Your Ref: OWPC20353
Our Ref: W/114/18/PL 08-08-2018
Please ask for:
Mrs A Gardner

Town & Country Planning Act 1990 (as amended)
Town and Country Planning (Development Management Procedure) (England) Order 2015

1 No. replacement dwelling.
5 Central Drive Middleton-On-Sea

PROJECT TITLE Proposed development at 5 Central Drive	DRAWING TITLE Proposed Elevations		No	REVISION	DATE
	STATUS Planning Application				
	SCALE 1:100 @ A3	DATE 20.07.2018			
	DRAWN BY AP	DRAWING No PA-270-07

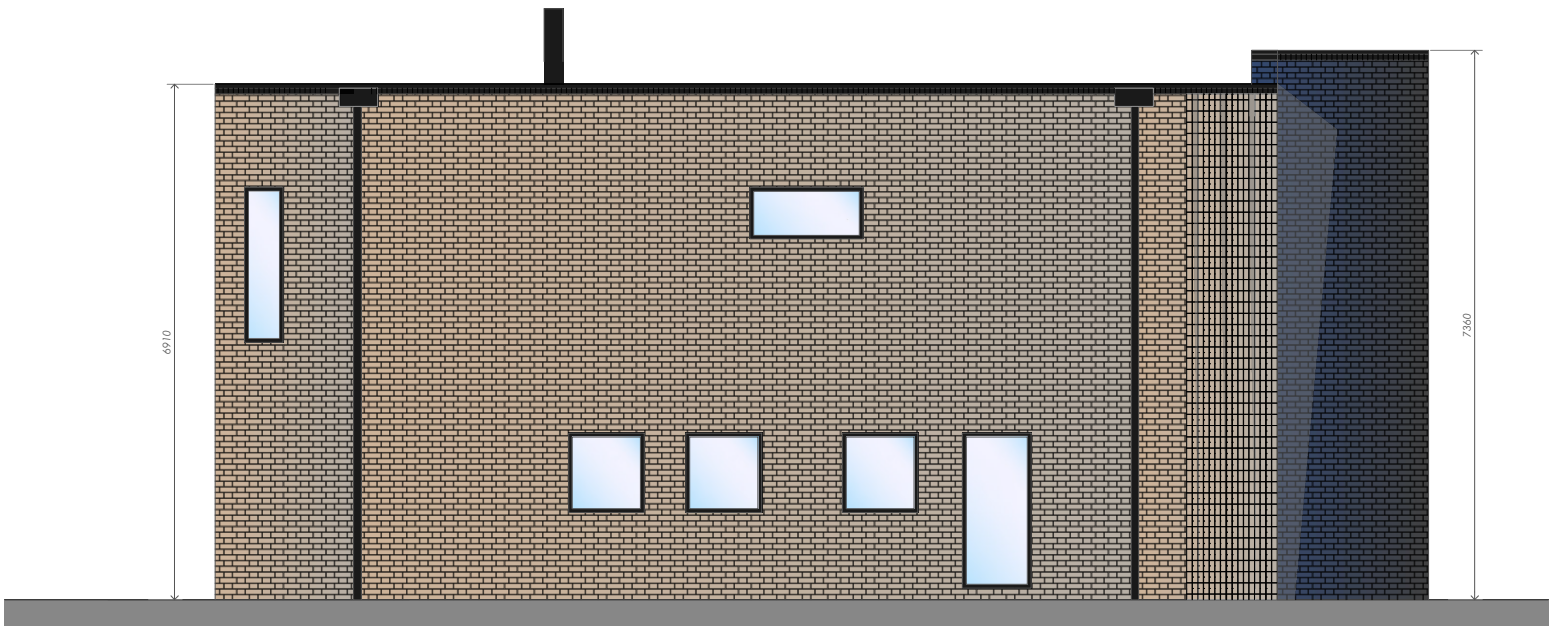
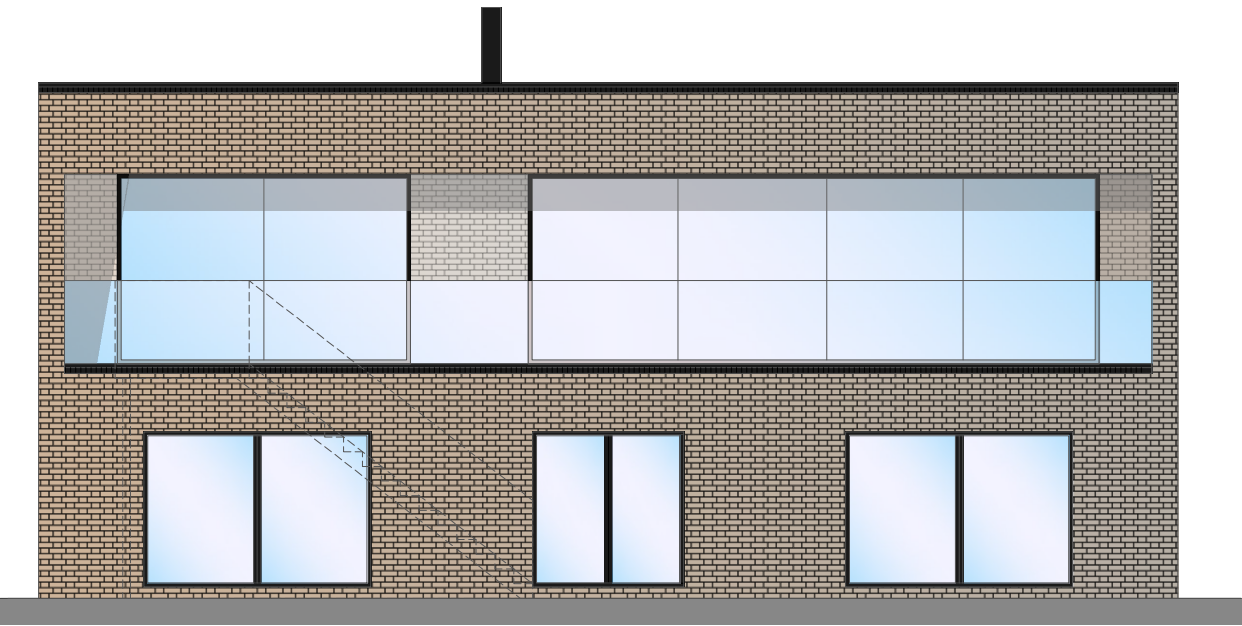
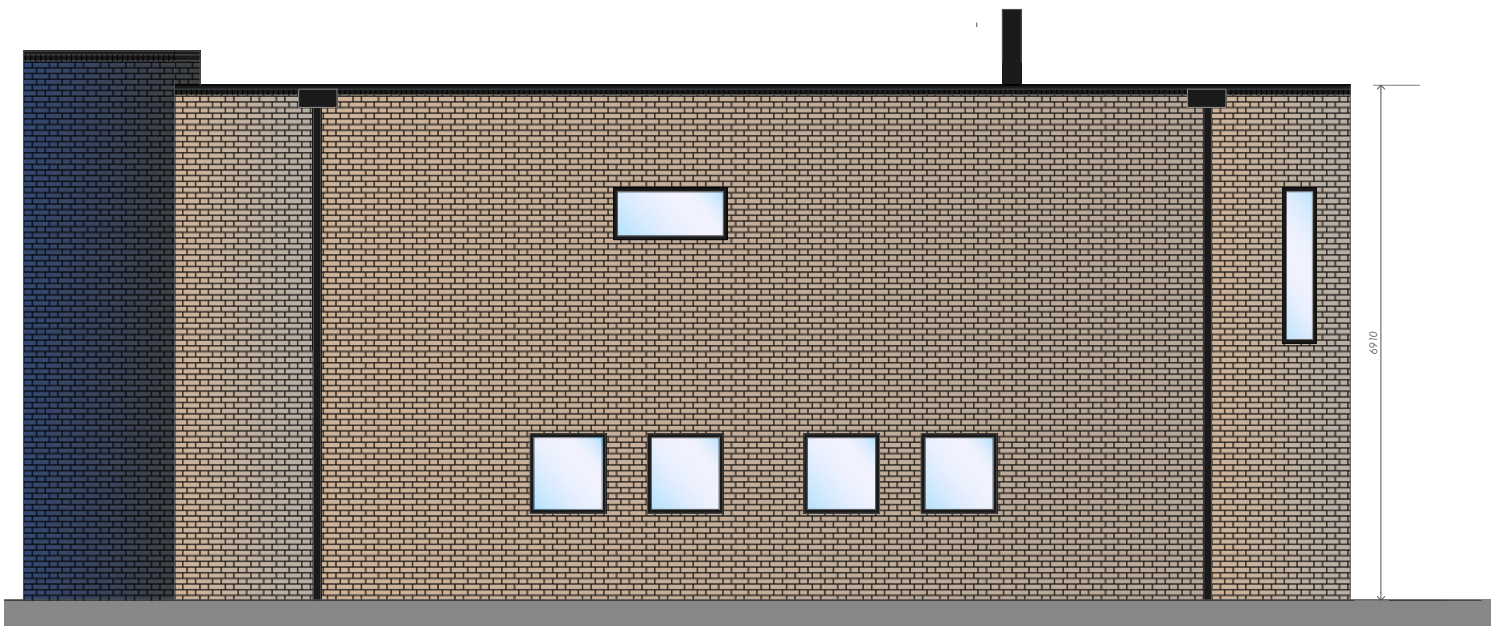
Replacement of the present very run-down building is welcome. However the proposed design is totally out of sympathy with its proposed context. There is one flat roofed building on the estate but all the others have pitched roofs and the proposed design would be very much more prominent. In particular however the materials and the way they are to be used are grossly out of place. Dark blue and "sandy-coloured" bricks as illustrated on the application are at odds with this seaside location and have no parallel in the nearby area. This finish, in combination with a generally forbidding appearance from the road mean that this building would dominate its immediate surrounds in a manner which is totally out of keeping with this small private estate.
